Preferred Project & Response to Submissions Report Section 75W Modification Major Project MP08_0244 (MOD 2)

23-37 Lindfield Avenue, 7 and 11 Havilah Lane

Mixed Use Development

March 2015 ■ 14416

1 HAVILAH LA ELEVATION
 2001 SCALE 1 : 250

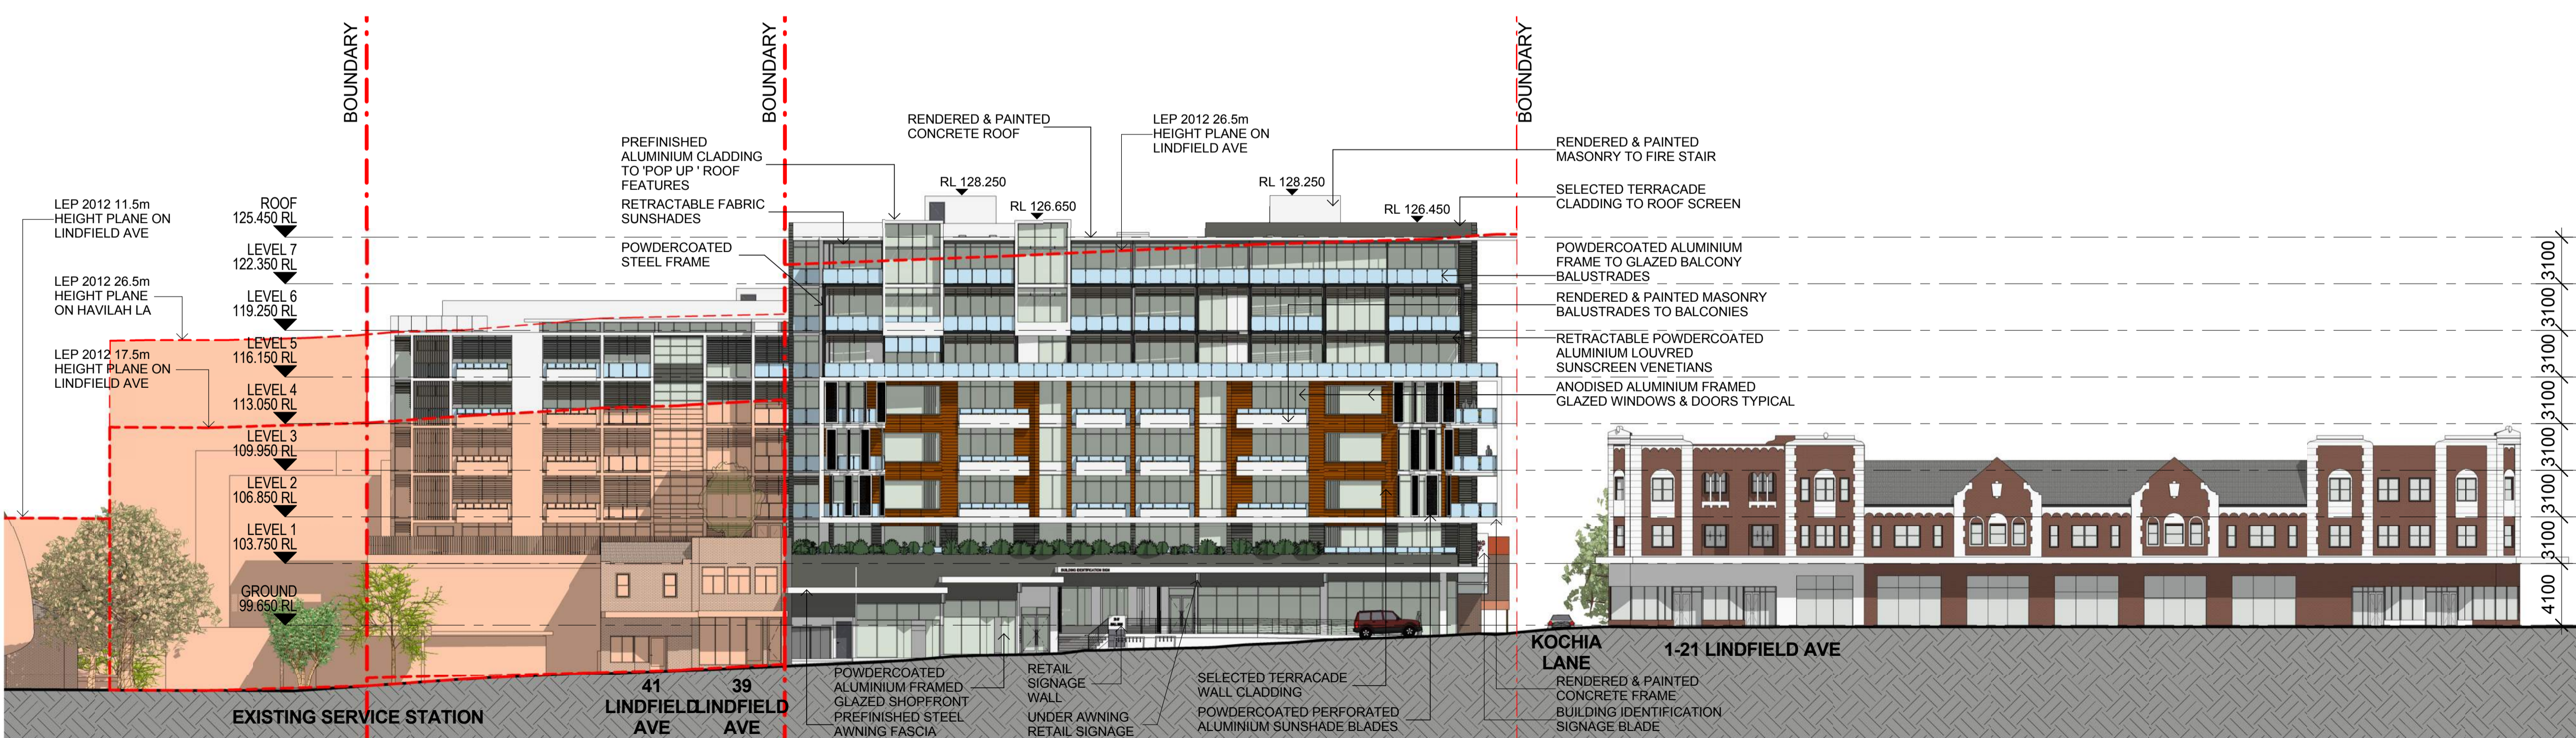
The proposed façade treatment at Havilah Lane should be reviewed and reconsidered to provide greater articulation to reduce the scale and visual bulk presented to Havilah Lane.

Revised Architectural Plans, prepared by Crone Partners are included at **Appendix A**. The proposed treatment of the Havilah Lane façade has been reviewed. In order to provide greater articulation of the ground floor and residential levels above, without affecting the amenity of the proposed apartments, the following amendments have been made:

- the colour of the terracade wall cladding has changed from grey to terracotta;
- the horizontal sun shade elements have been introduced above each of the windows on the recessed terracade sections; and
- notches have been incorporated in the roof framing feature to provide further articulation in the horizontal roof lines of the façade.

2 LINDFIELD AVE ELEVATION
 2001 SCALE 1 : 250

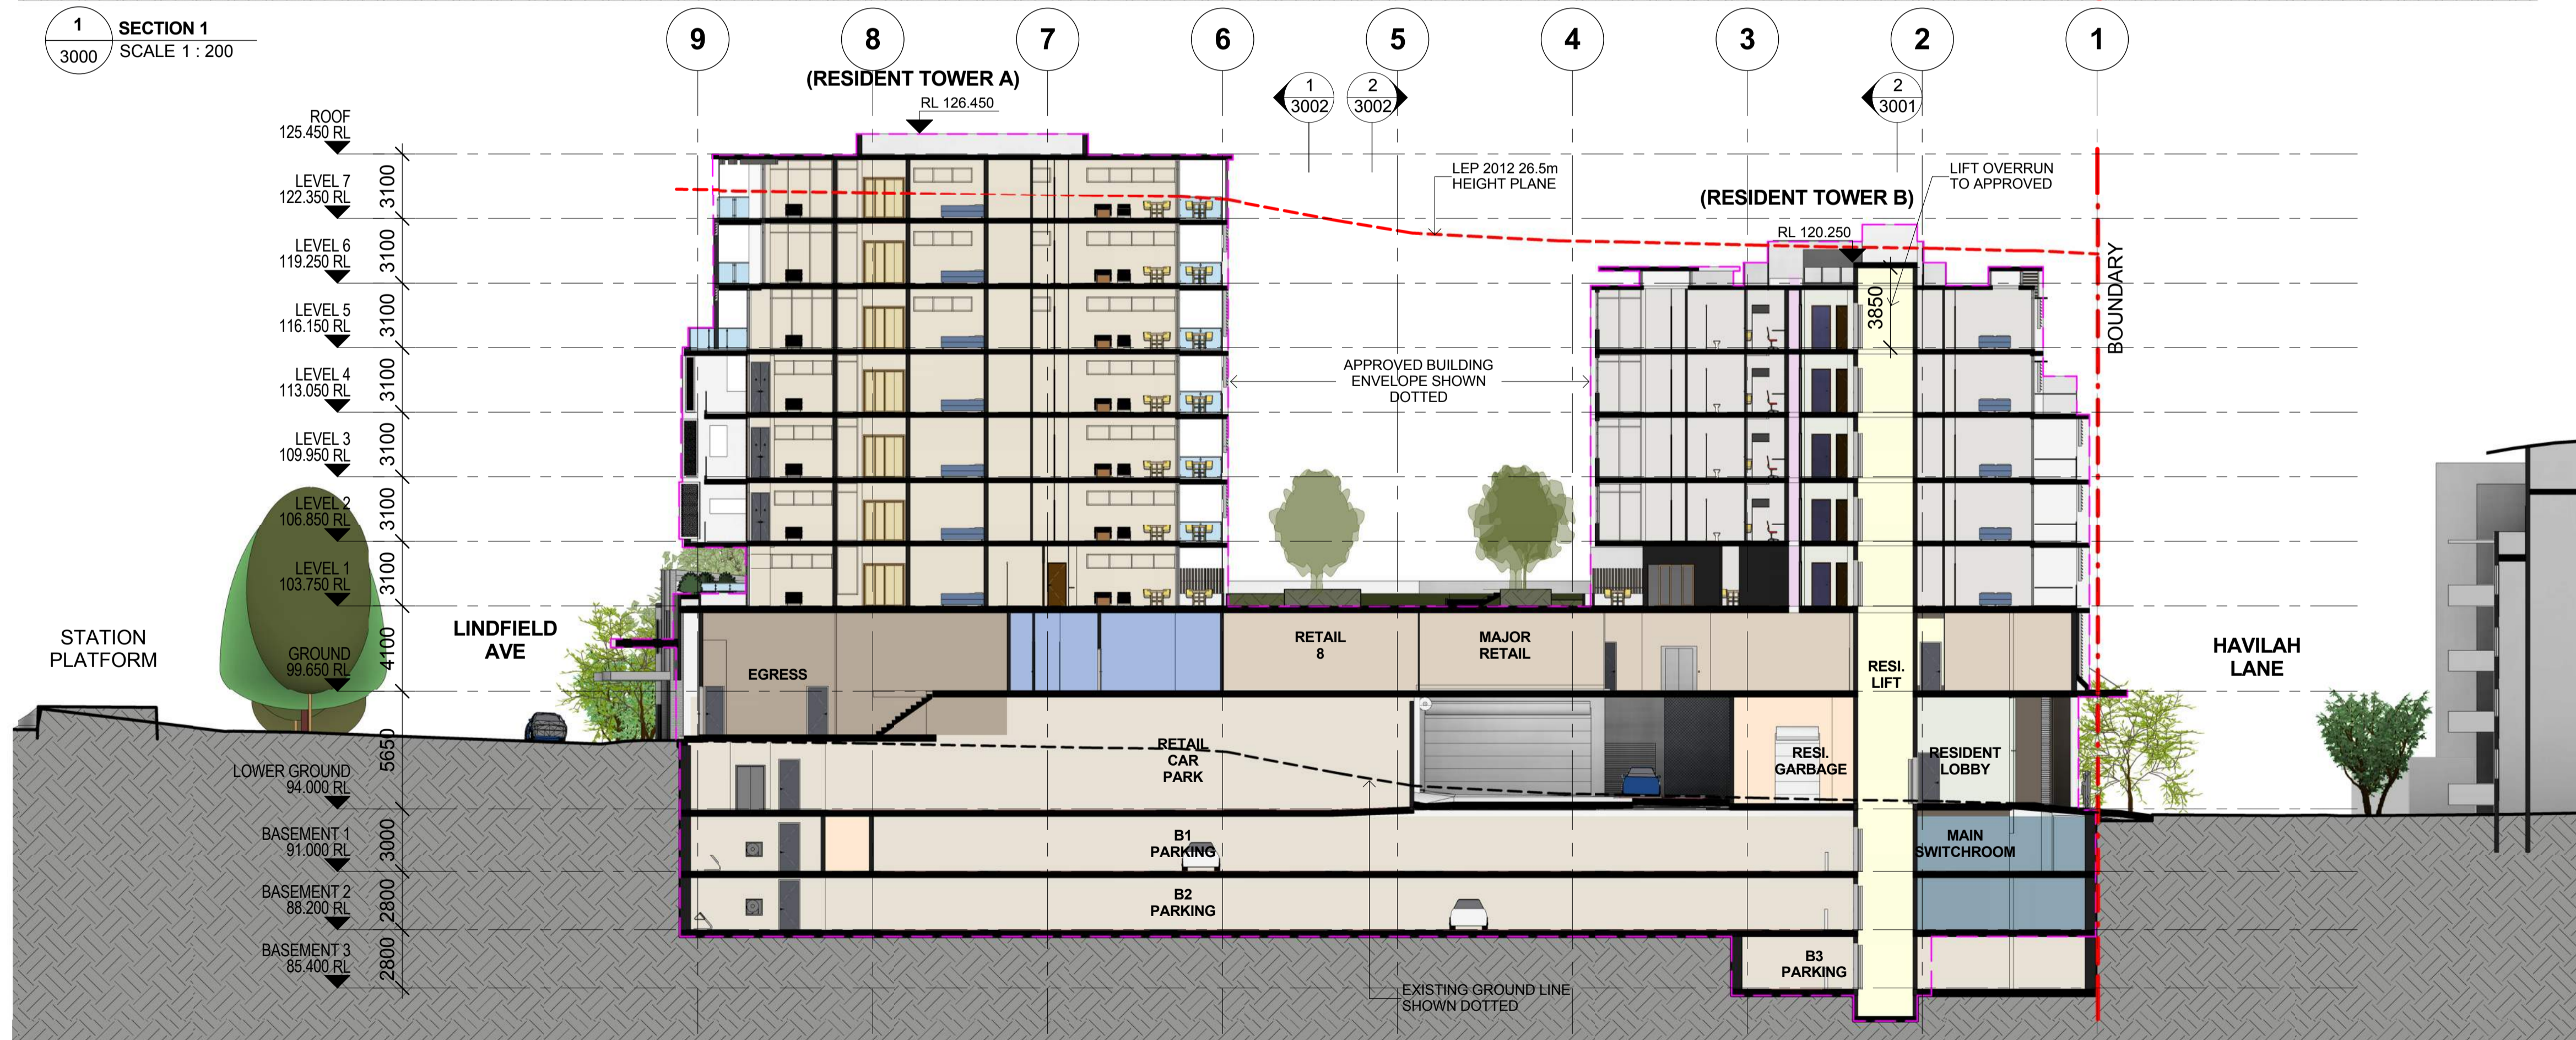
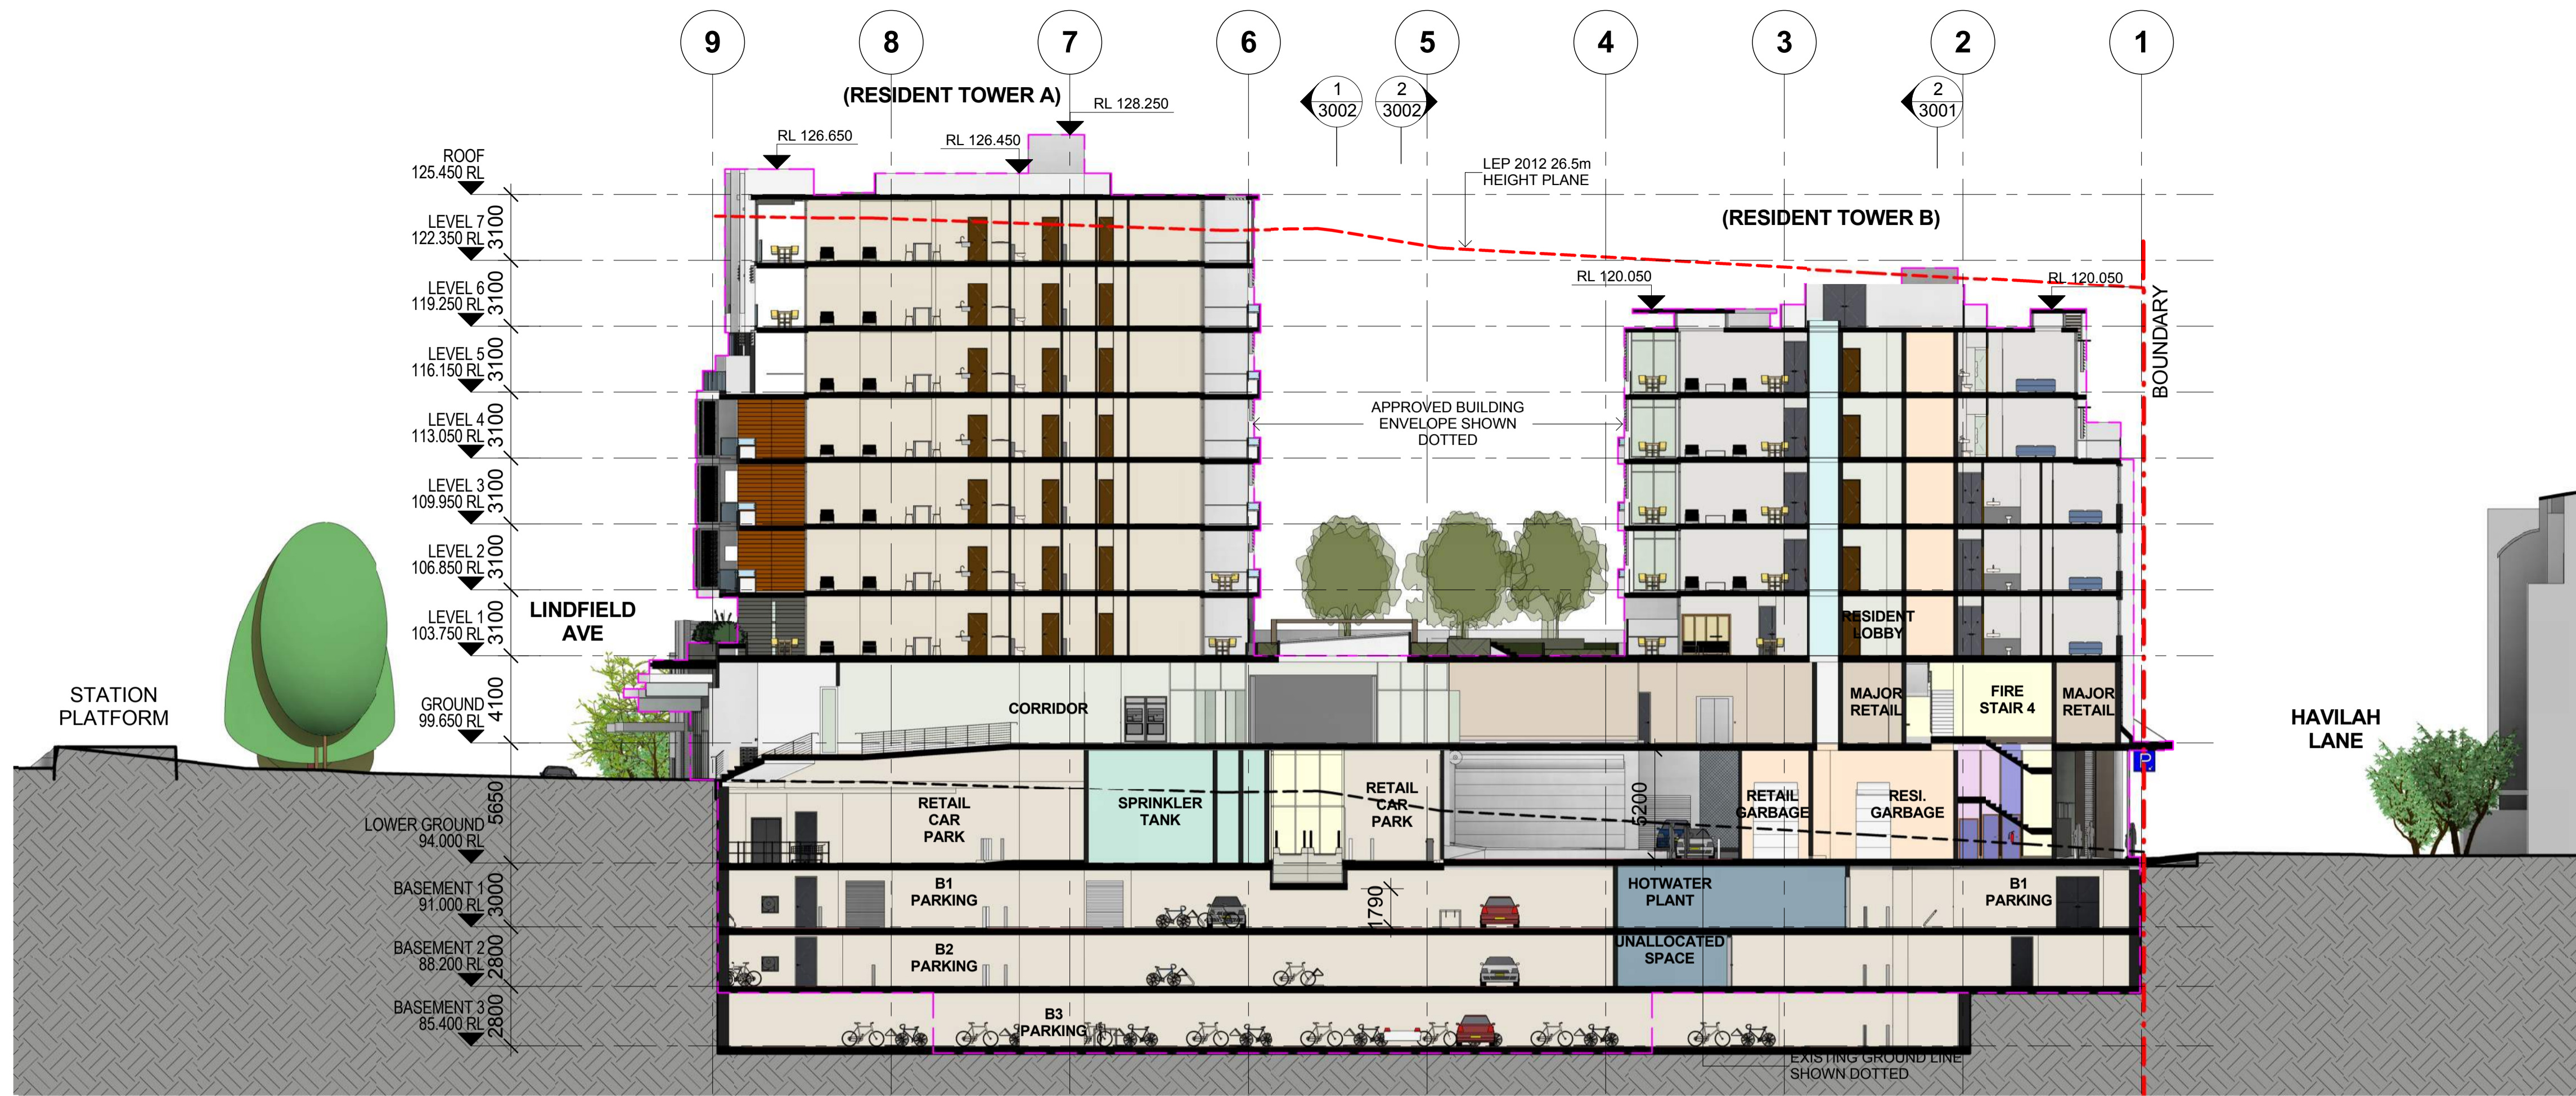
The pedestrian ramp fronting retail tenancies 3 and 4 at Lindfield Avenue should be relocated to provide a zero setback at the street edge to allow activation of Lindfield Avenue and consistency with the current and future street edge.

The proposed design of the pedestrian ramp fronting retail tenancies 3 and 4 on the Lindfield Avenue frontage has been amended to reflect the design which was approved under the MOD 1 PPR. The ramp is now proposed to be internalised and a 'zero' setback to Lindfield Avenue proposed at the Ground Floor Level. Refer to amended architectural plans at **Appendix A**.
